## **Able Marine Energy Park**

### *Material Change 2*

**Proposed Able Marine Energy Park Material Change 2**  
**Application ref: TR030006**  
**Applicant's Submissions - 16 March 2022 - document ref TR030006/Cover**

**Able Marine Energy Park 2021 Report DER6453-RT006 R01-00 Modelling of Sediment Plume Dispersion from AMEP Construction Activities**

Figure 6.8: Predicted increase in suspended sediment concentration at high water on a spring tide

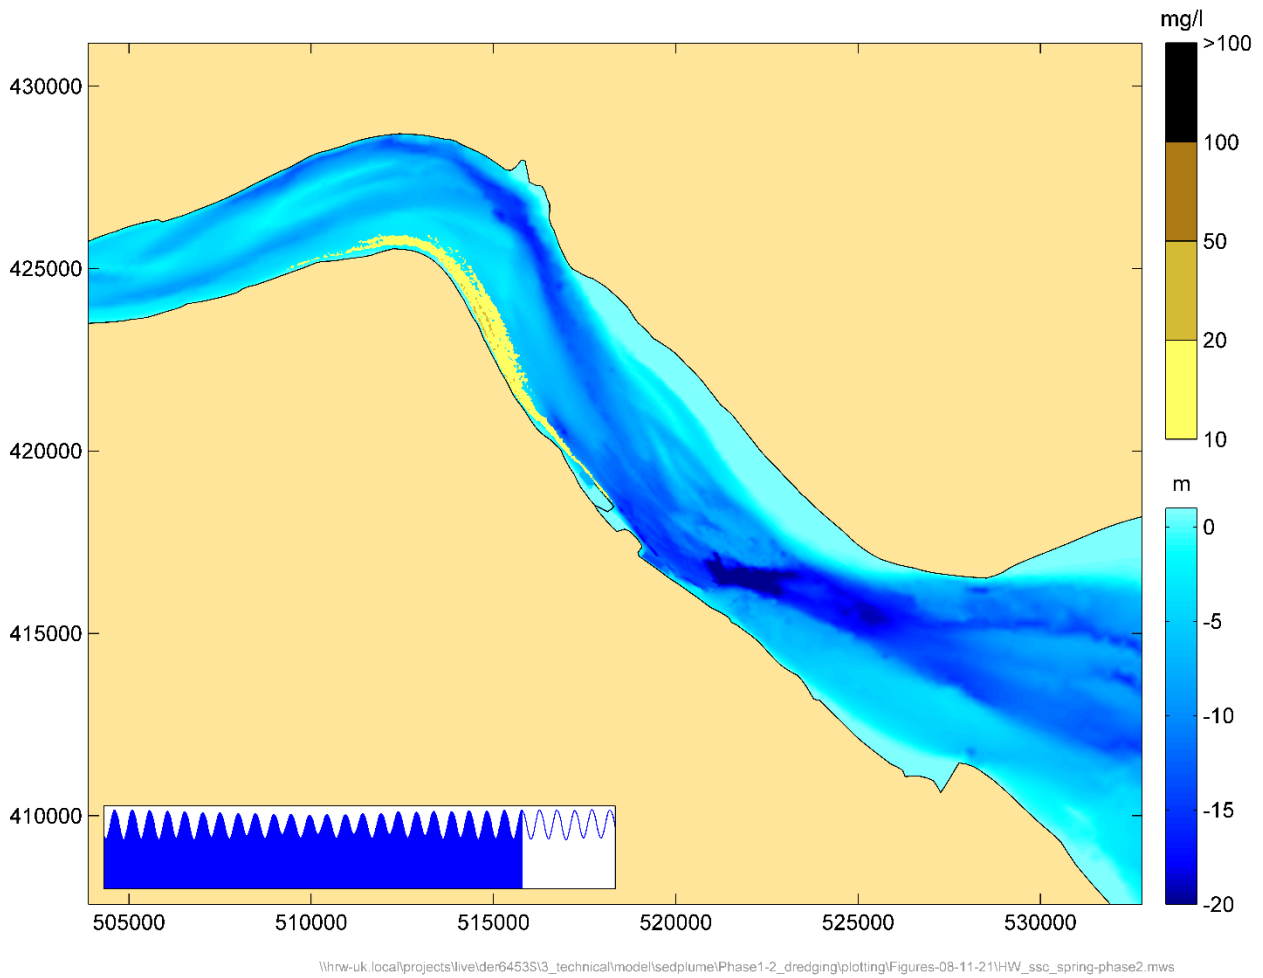
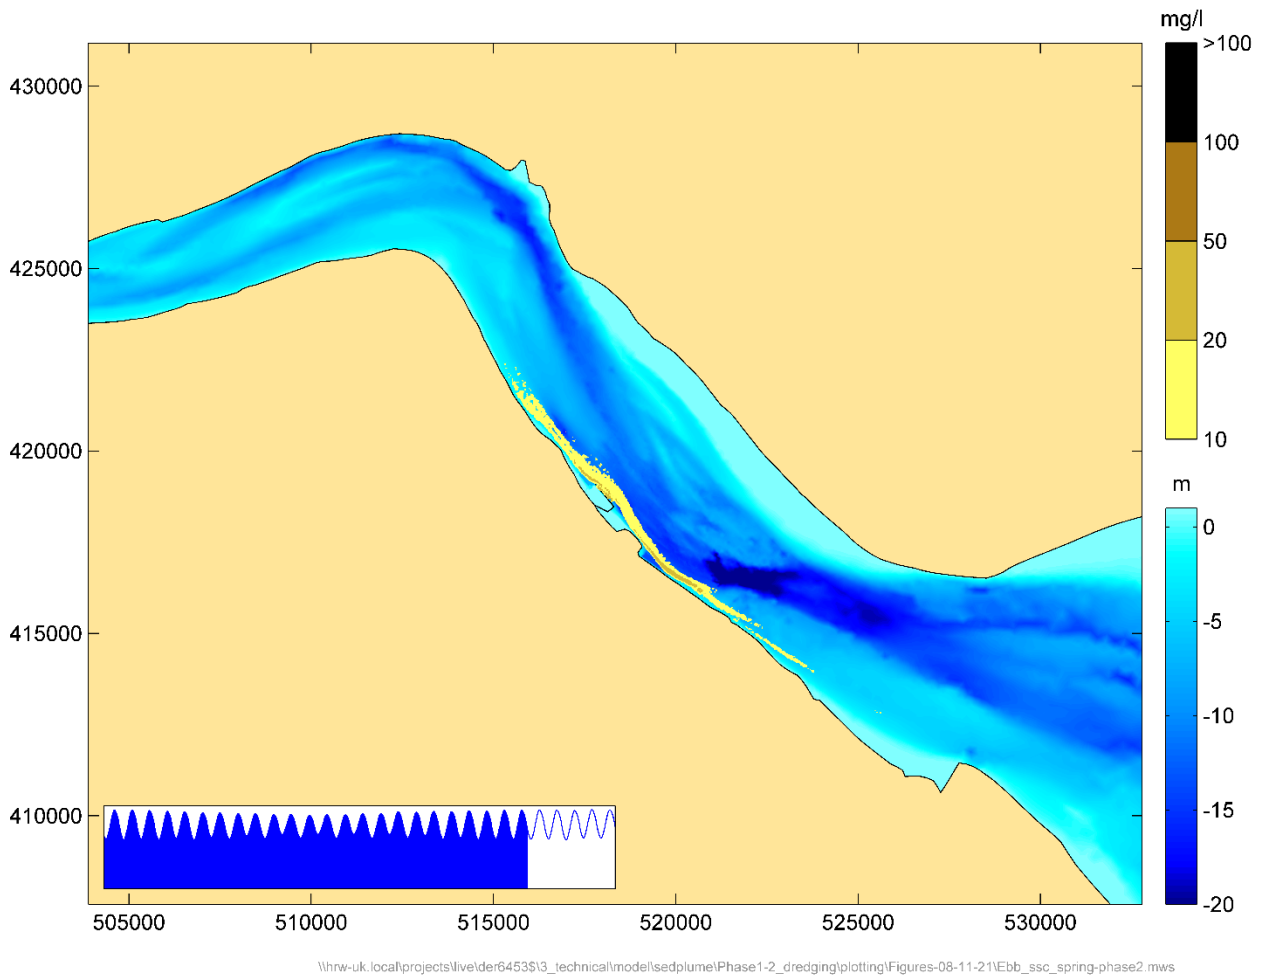
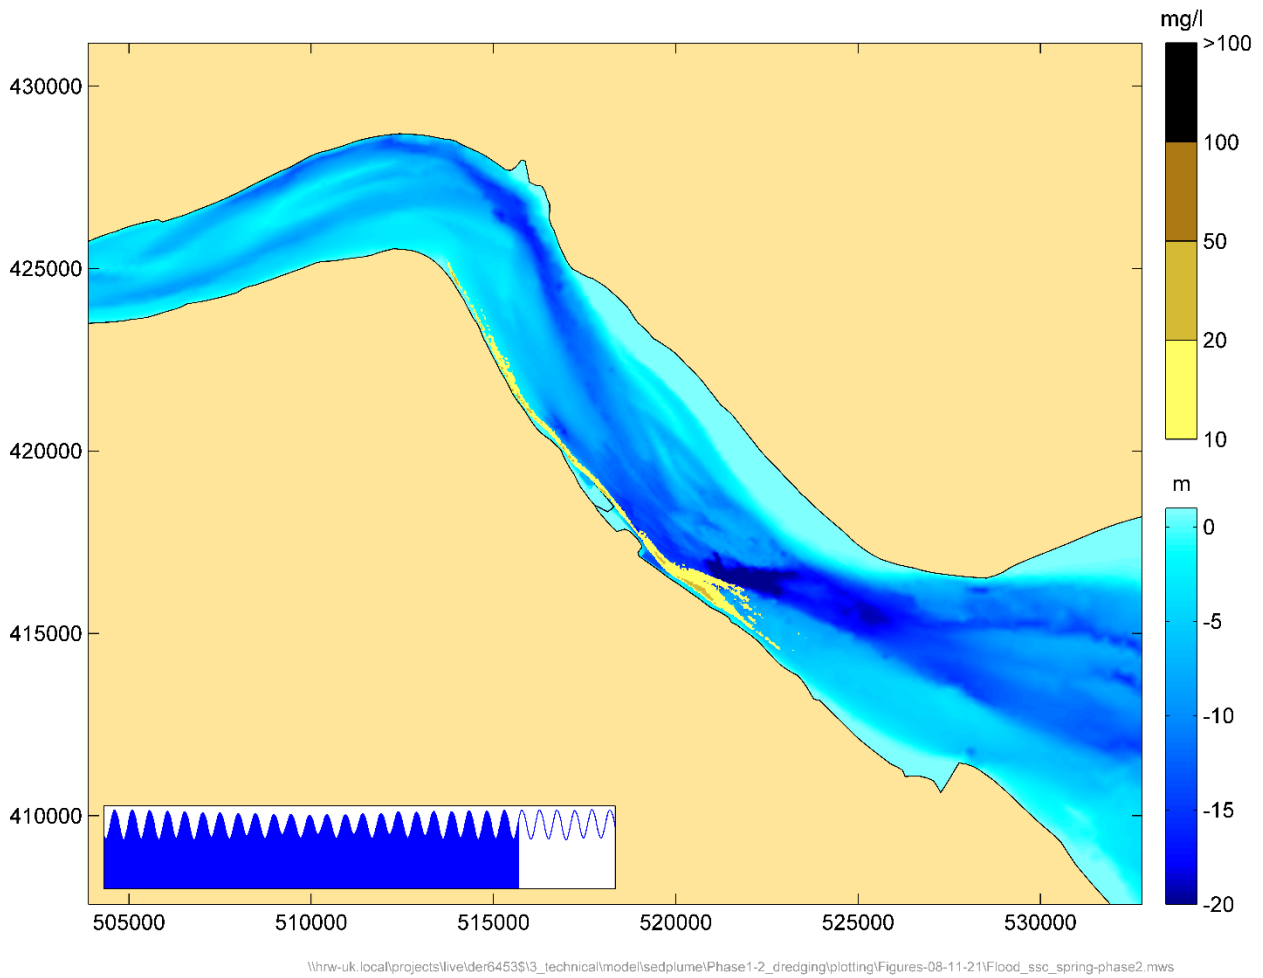
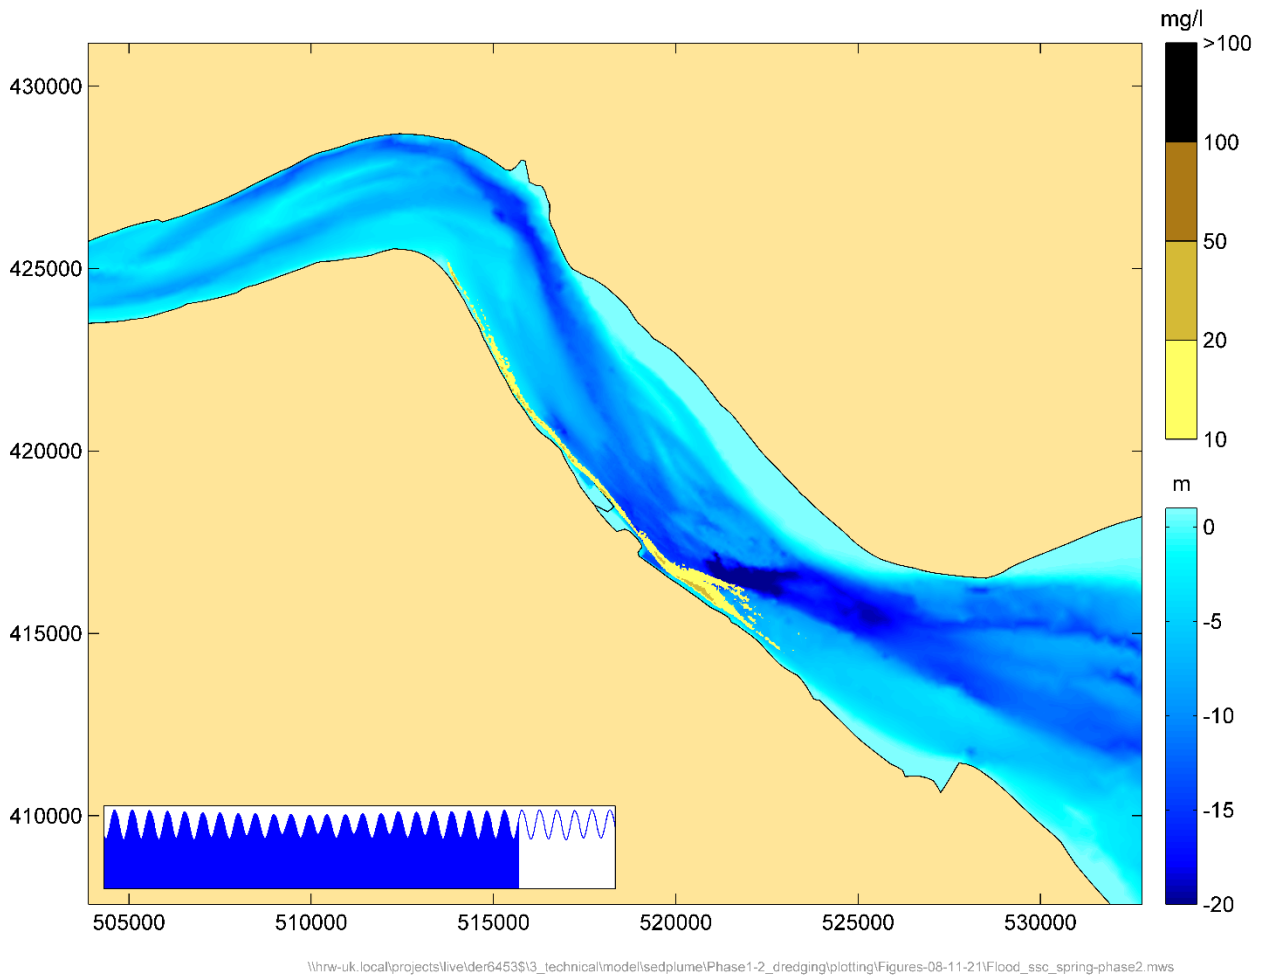
<p><u>HR Wallingford response:</u> The SEDPLUME model is described in Section 2 of the earlier report (HR Wallingford Report DER6453-RT002-R04-00, June 2021).</p>
Section 6.3.1, 1 <sup>st</sup> Paragraph	<p>This refers to Figure 6.4, but should refer to Figures 6.8-6.11.</p> <p><u>HR Wallingford response:</u> Correct.</p>
Section 6.3.1, 2 <sup>nd</sup> Paragraph	<p>This refers to Figure 6.5, but it should refer to Figure 6.12.</p> <p><u>HR Wallingford response:</u> Correct.</p>
Figure 6.12	<p>The peak increase in depth-averaged SSC near the AMEP site appears insignificant compared with measured background SSCs and we understand that background SSC levels further up the estuary can reach thousands of mg/l. However, at Grimsby this is not the case. Peak surface concentrations of 150-200mg/l were recorded at Grimsby in 2009. Figure 6.12 shows predicted peak increase in SSC of 10-20mg/l at Grimsby but 20-50mg/l just to the north of Grimsby. These values relate to 5-33% increase above the 2009 peak surface concentrations which could be considered significant.</p> <p><u>HR Wallingford response:</u> NE is referred to Chapter 10, Section 10.4.0 of the UES with regards to the significance of any impacts of elevated levels of SSC on the marine environment. Specifically, paragraph 10.4.24 states:</p> <p><i>'The ecological effects associated with the proposed material change will be substantially similar in nature to those considered in the original ES, with no new effects having been identified'.</i></p> <p>The highest increases in suspended sediment concentrations in the vicinity of Grimsby arose from the scenario of the TSHD dredging sand and gravel. In the earlier studies it was found that the effects of dredging with the amended AMEP scheme were comparable to the consented scheme (see Figures 9.5 to 9.8 of the earlier study). No previous concerns about elevated peak suspended sediment concentration in the vicinity of Grimsby have been raised by Natural England, the Environment Agency or the MMO.</p>
